Date: 07-Aug-2026
Our Ref: 2026/90302

**PRIOR APPROVAL FOR ALTERATIONS TO BRIDGE MVL3/65, LEES MILL LANE, WEST OF SLAITHWAITE
ADJ, BANK LEES, SLAITHWAITE, HUDDERSFIELD, HD7 4HB
APPLICATION NO: 2026/90302**

Drawing Title
**Prior Approval -
MVL3/65 Lees Mill Lane -
Existing and Proposed
Elevation and Section**

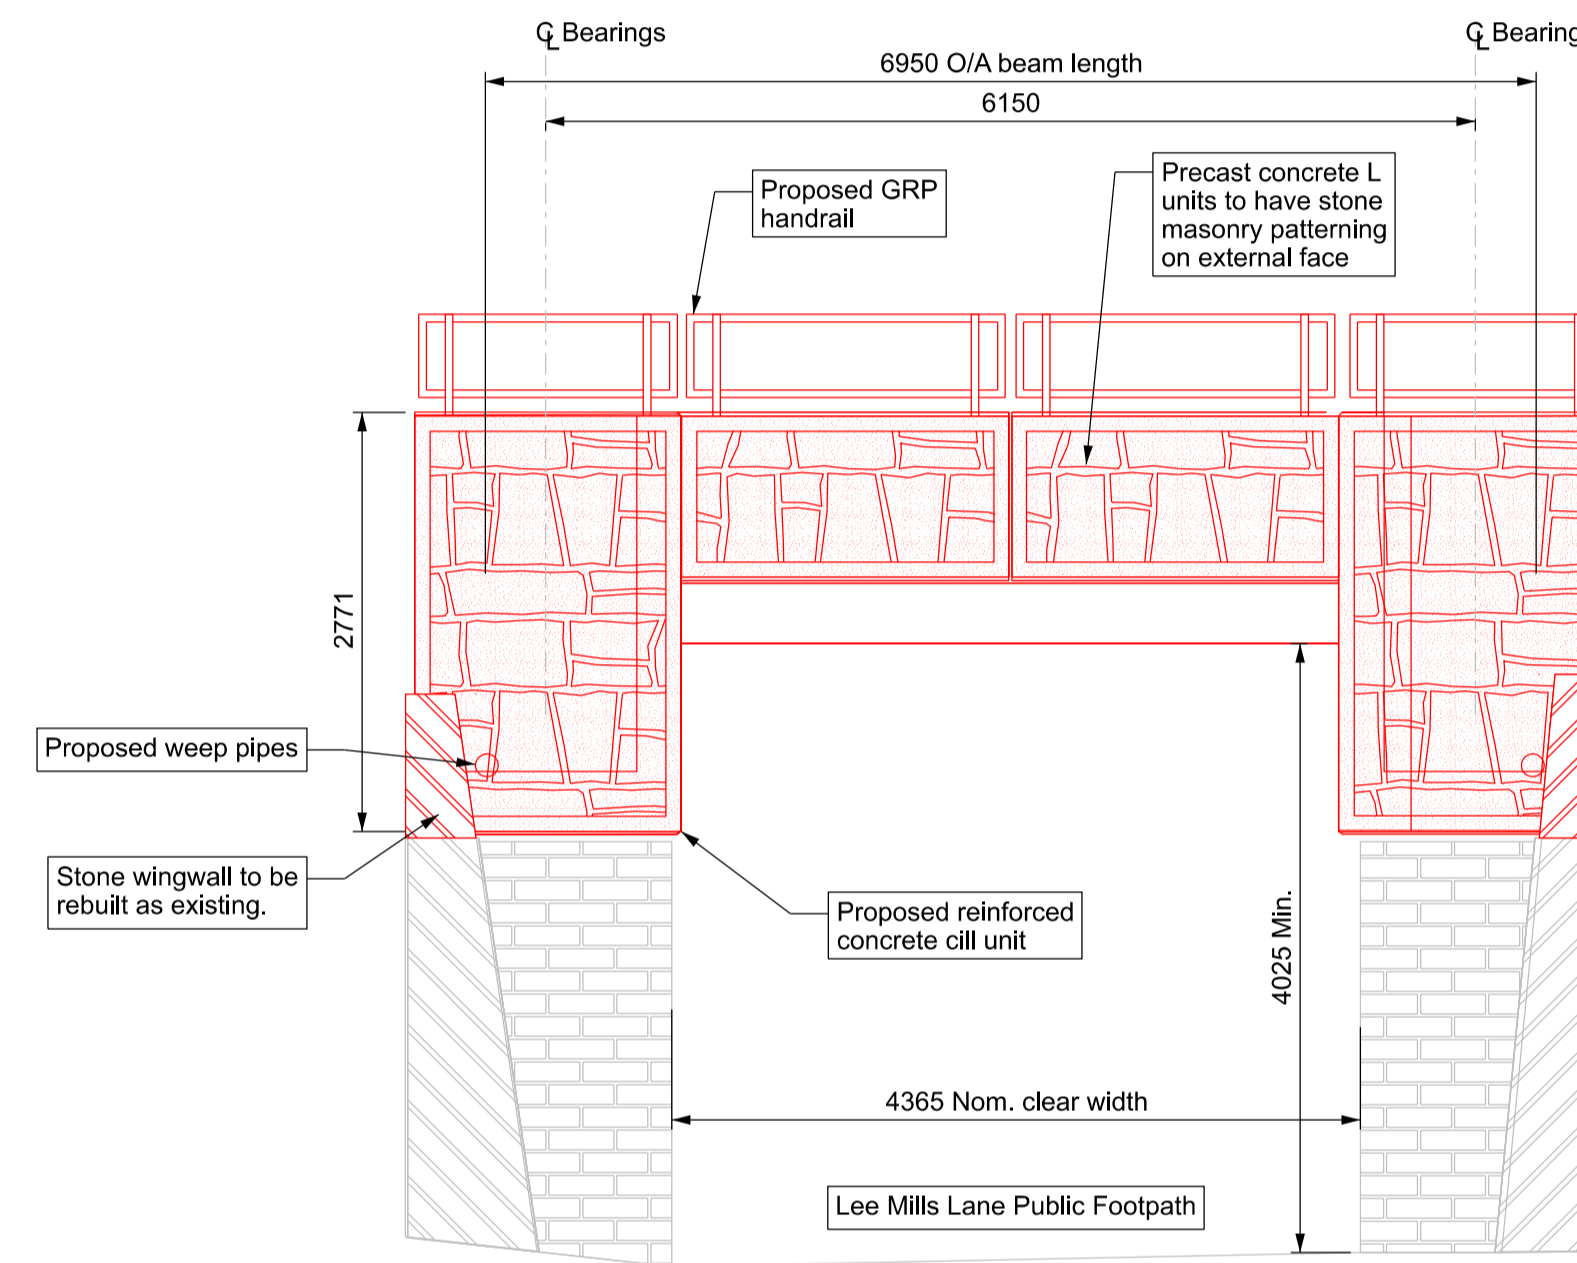
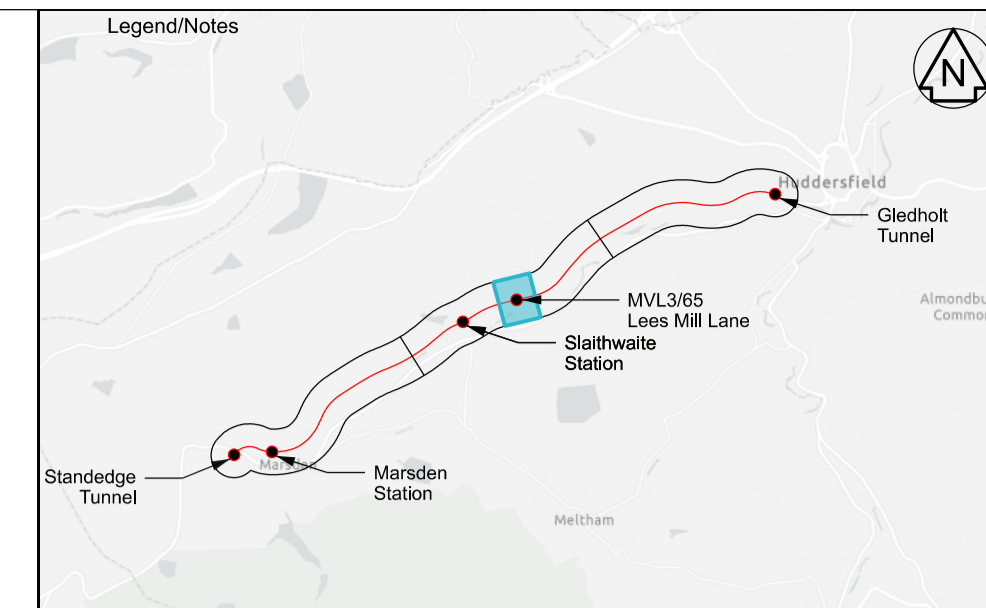
1. Notwithstanding the submitted plans, a sample of the parapet finish[es] shall be submitted to and approved by the Local Planning Authority, prior to their installation. The external treatment of the parapet finish[es] shall reflect the retained stonework of the bridge in terms of colour, texture, finish and coursing. Thereafter the development shall be implemented in accordance with the approved details.

2. The GRP handrail, as shown on plans ref. 167037-TGP-54-MVL3-DRG-T-LP-165600 rev. P02 and 167037-TGP-54-MVL3-DRG-T-LP-167601 rev. P02, shall be finished in a black or green powder coating
